Application by Frodsham Solar Ltd for Frodsham Solar (EN010153)

The Examining Authority's second written questions and requests for information (ExQ2): Issued on 13 March 2026

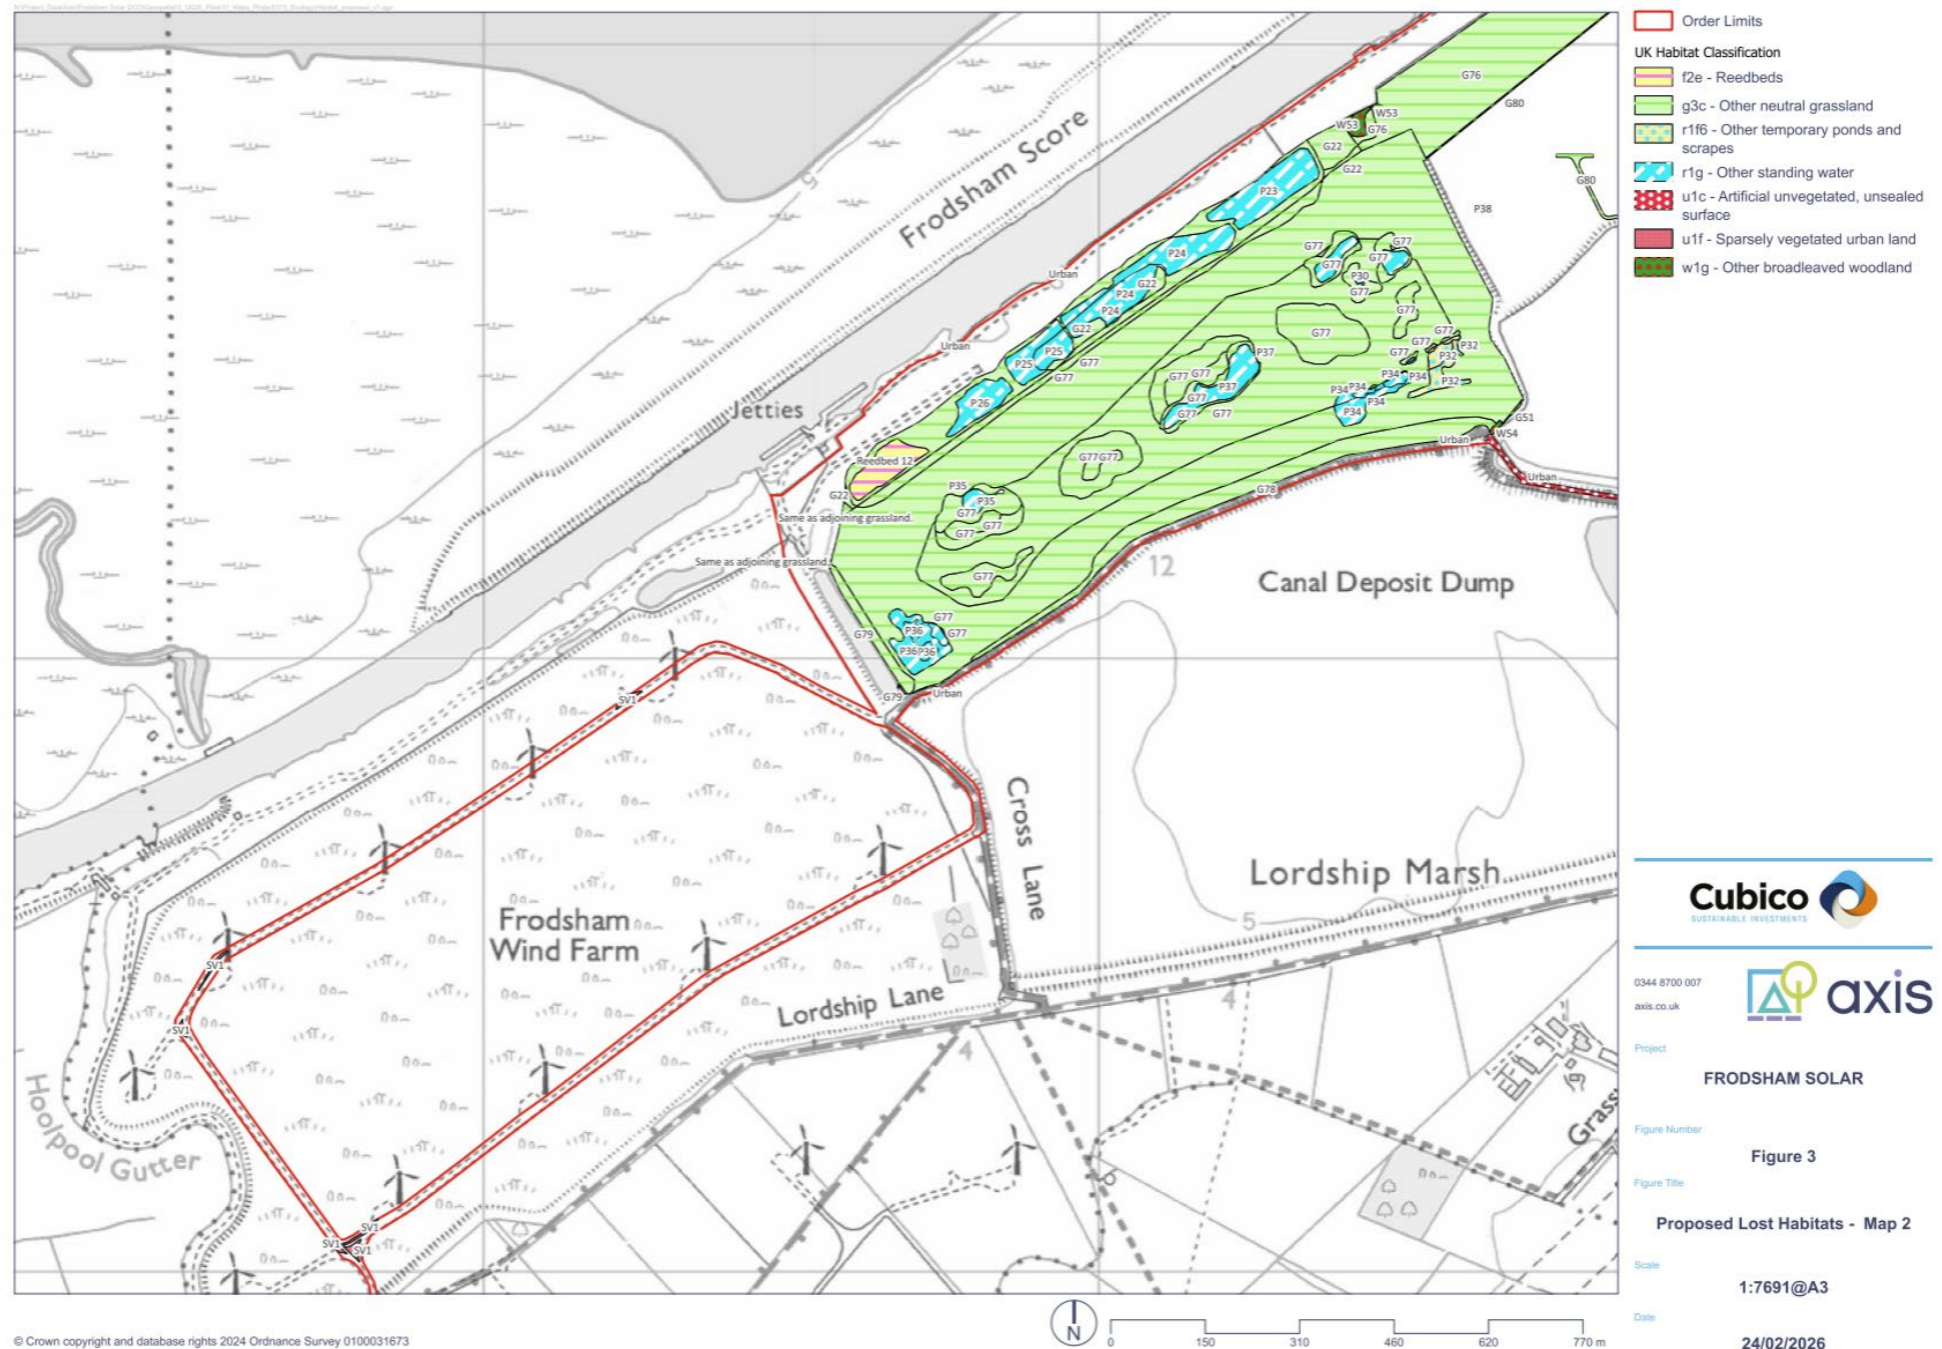
- 1) Can the applicant explain why post development there would be an increase in reedbed area but a decrease in reedbed units? What is it about the properties of the post development reedbed area that cause the calculation of resulting BNG units to fall?
- 2) The ExA acknowledges that BNG requirements are not yet mandatory for NSIP applications and that the applicant has clearly stated that the trading rules for reedbeds are not proposed to be met. Nevertheless, the mitigation hierarchy should still be adhered to. The ExA would like the applicant to explain how much reedbed is proposed to be lost for each of the areas given below and provide justification as to why these areas of reedbed are proposed to be lost and not retained:
 - a. Reedbed 12 shown in the NBBMA (see screenshot below from Map 2 of Figure 3 of the deadline 4 Biodiversity Net Gain Report [REP4-038])

b. Reedbed 40 (see screenshot below from Map 4 of Figure 3 of the deadline 4 Biodiversity Net Gain Report [REP4-038])

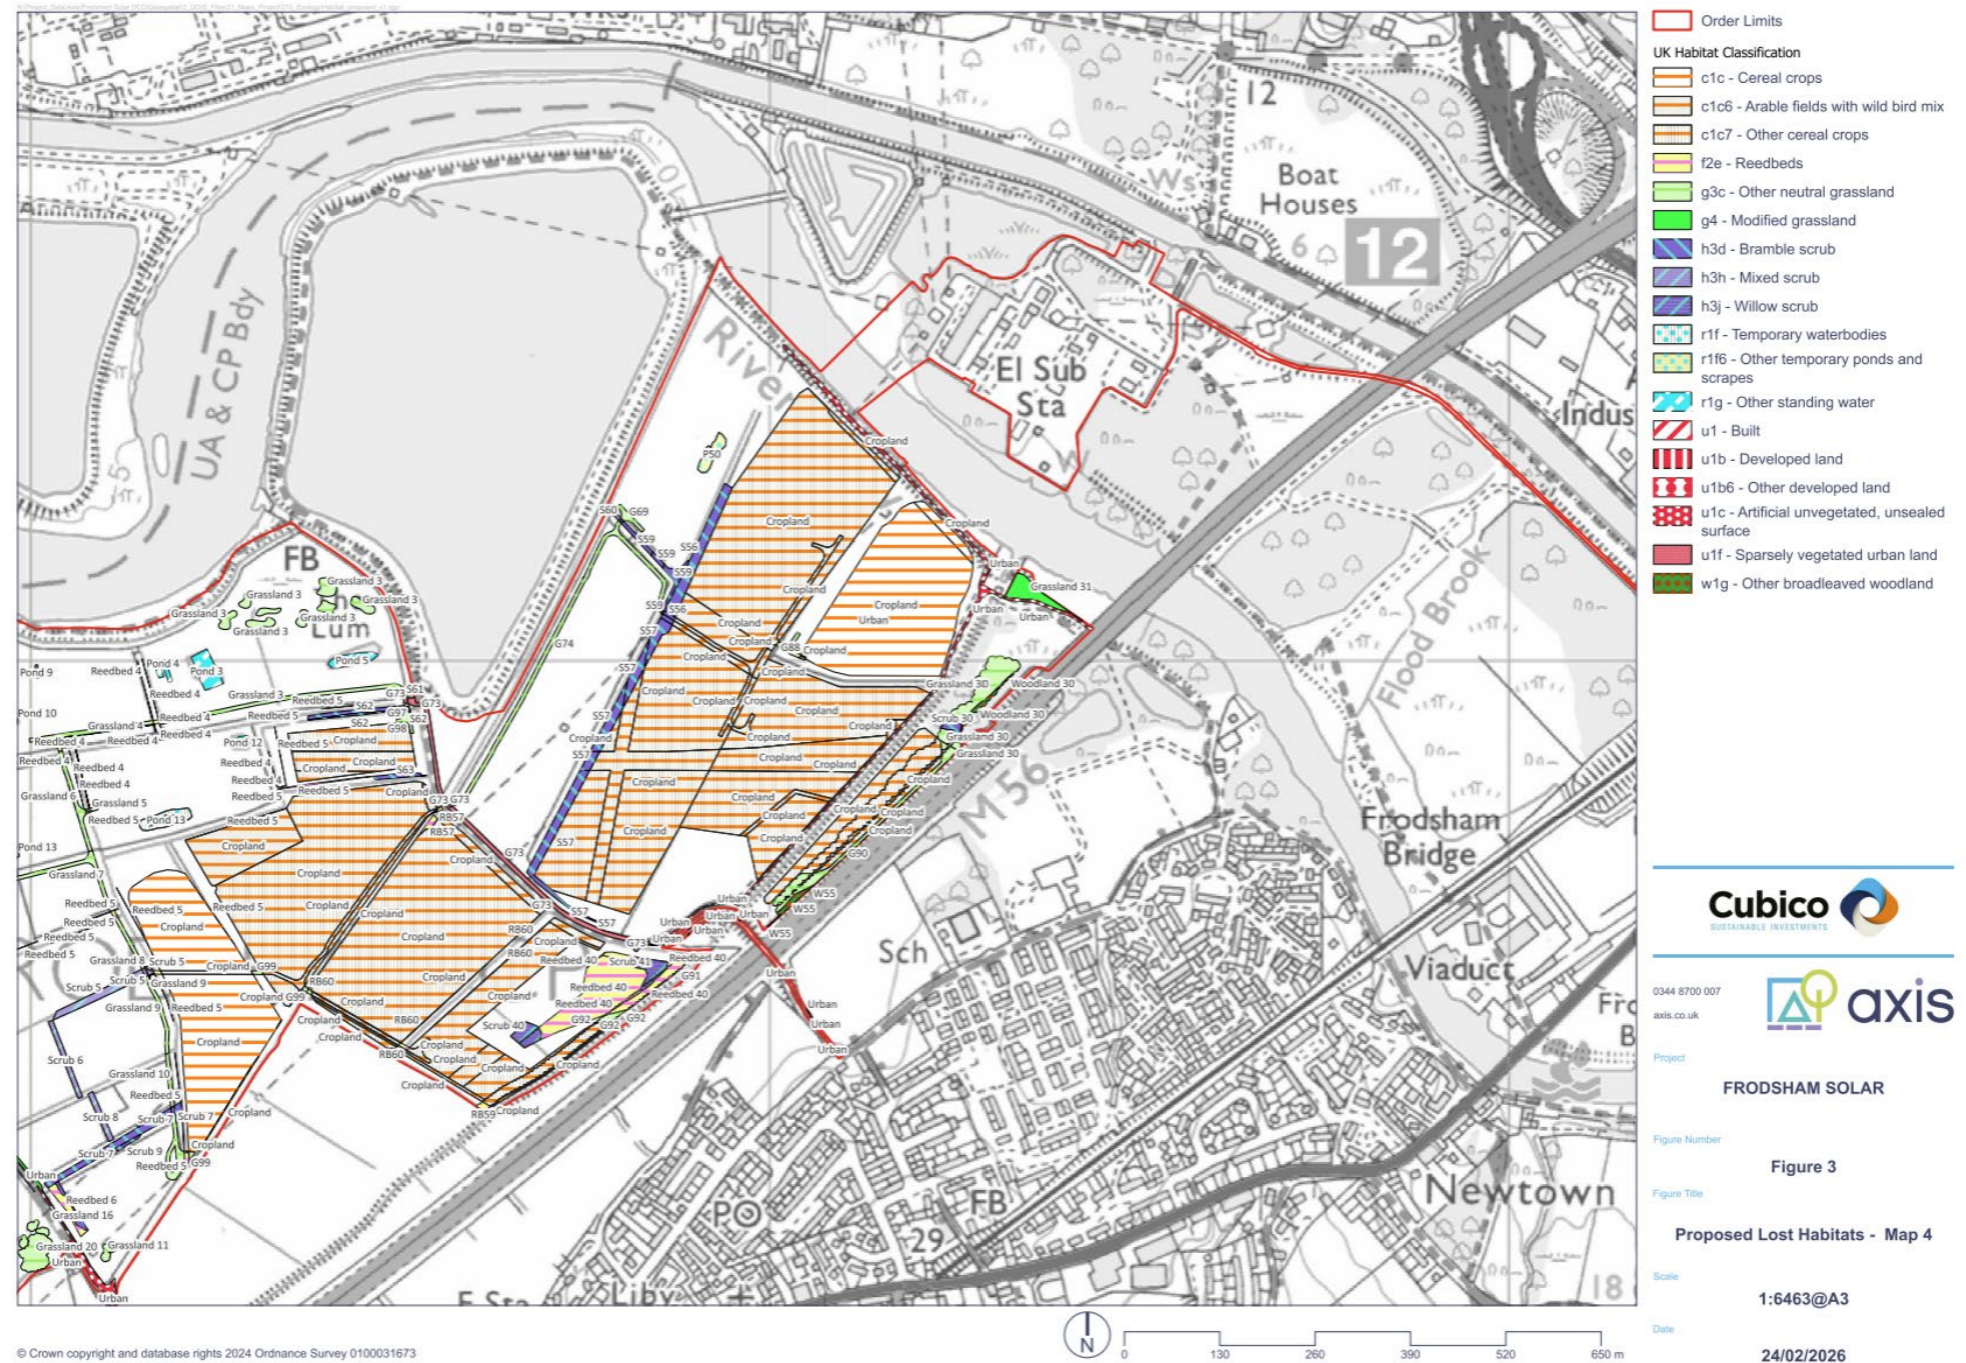
b. Reedbed 40 (see screenshot below from Map 4 of Figure 3 of the deadline 4 Biodiversity Net Gain Report [REP4-038])

c. Reedbed 7 near Marsh Farm (see screenshot below from Map 3 of Figure 3 of the deadline 4 Biodiversity Net Gain Report [REP4-038])

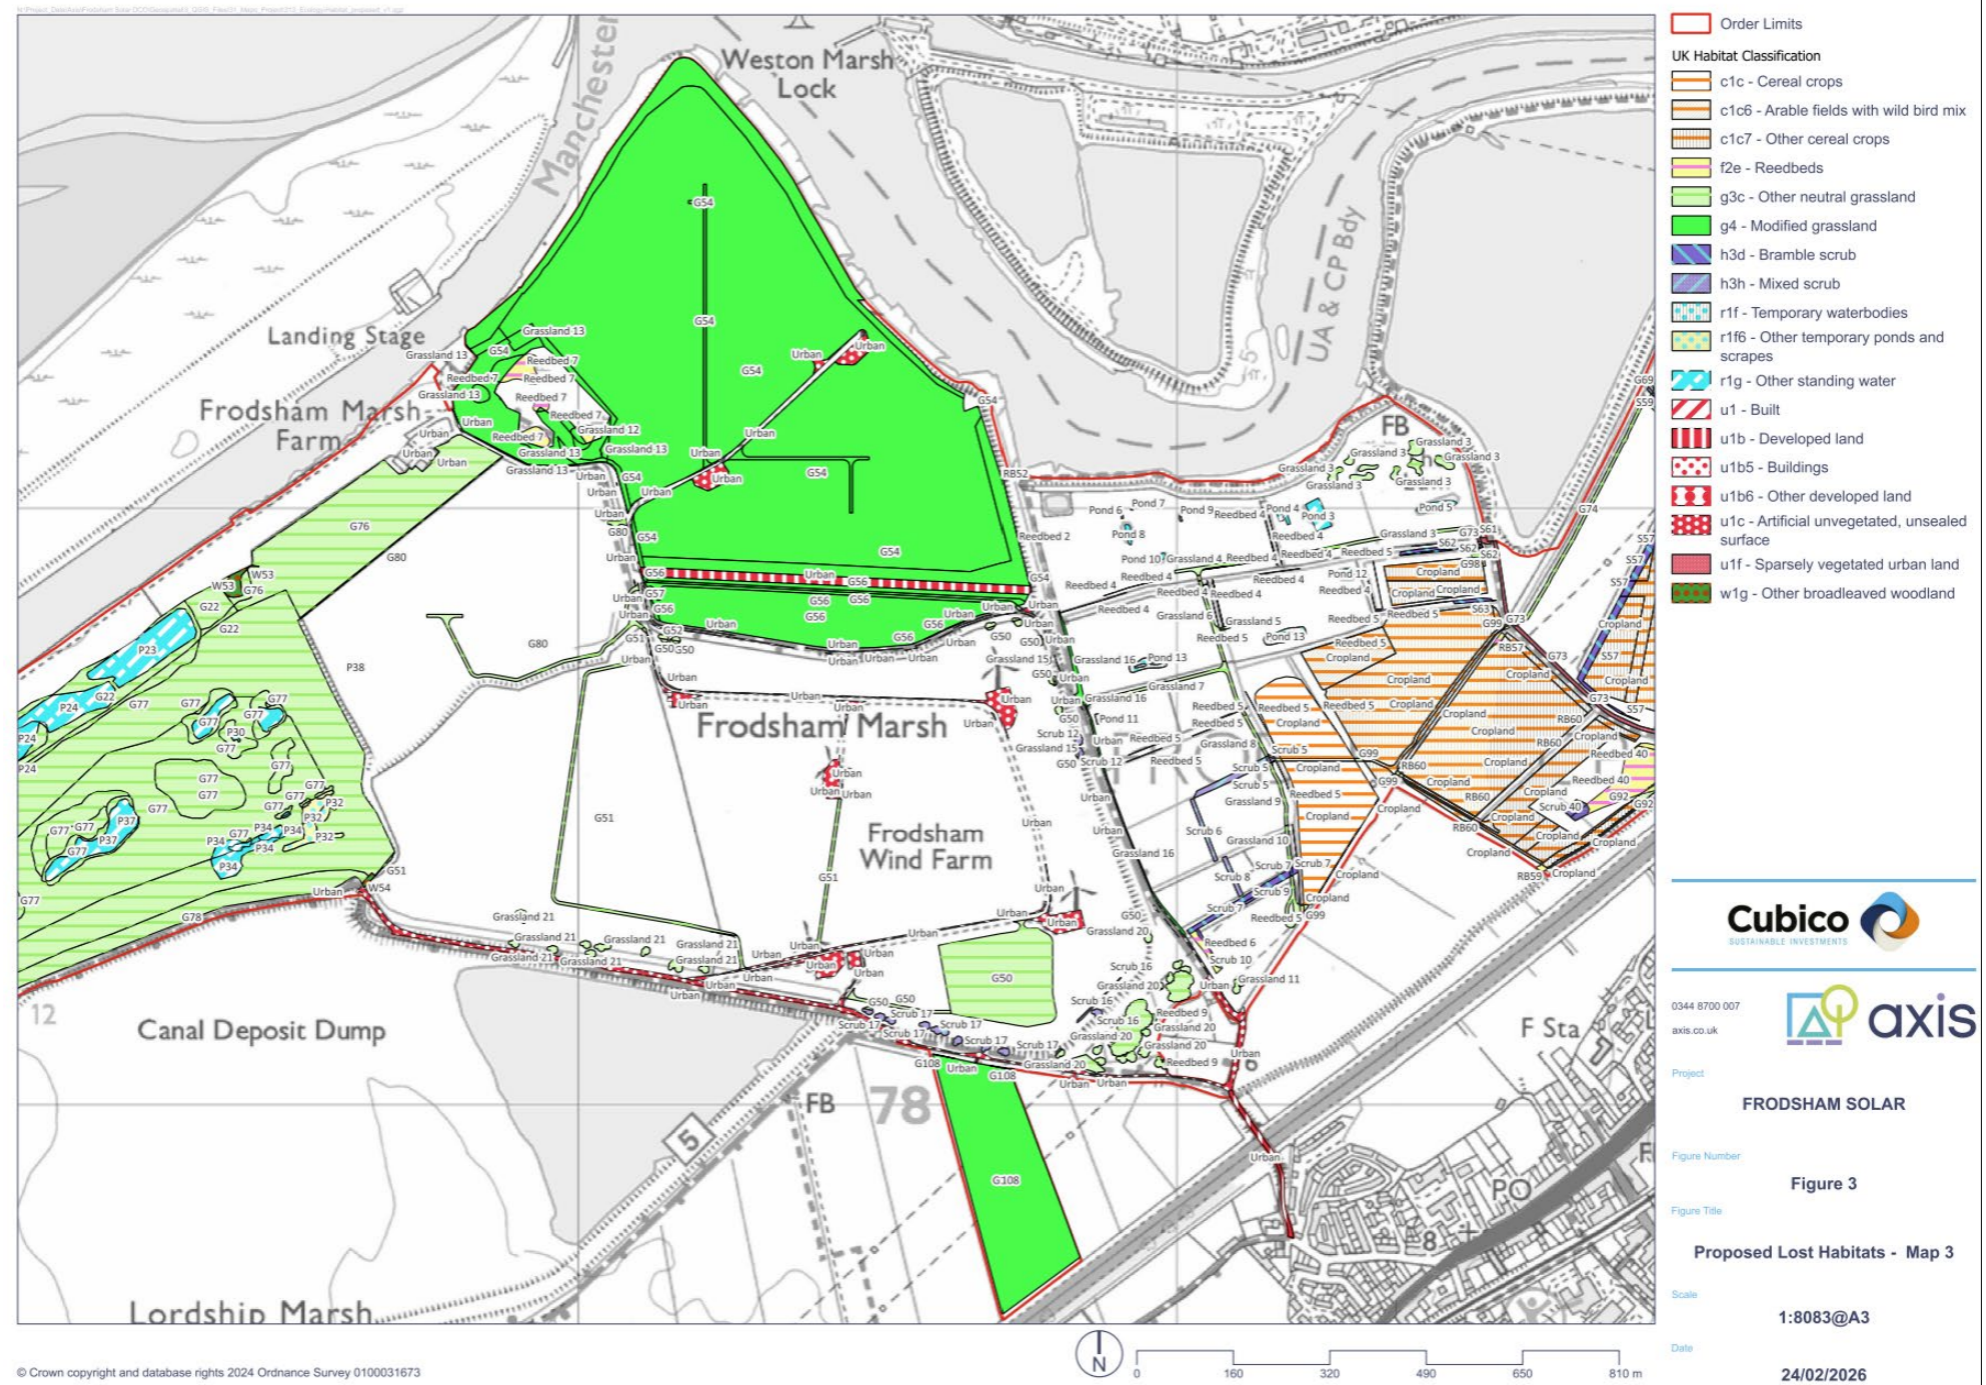
c. Reedbed 7 near Marsh Farm (see screenshot below from Map 3 of Figure 3 of the deadline 4 Biodiversity Net Gain Report [REP4-038])
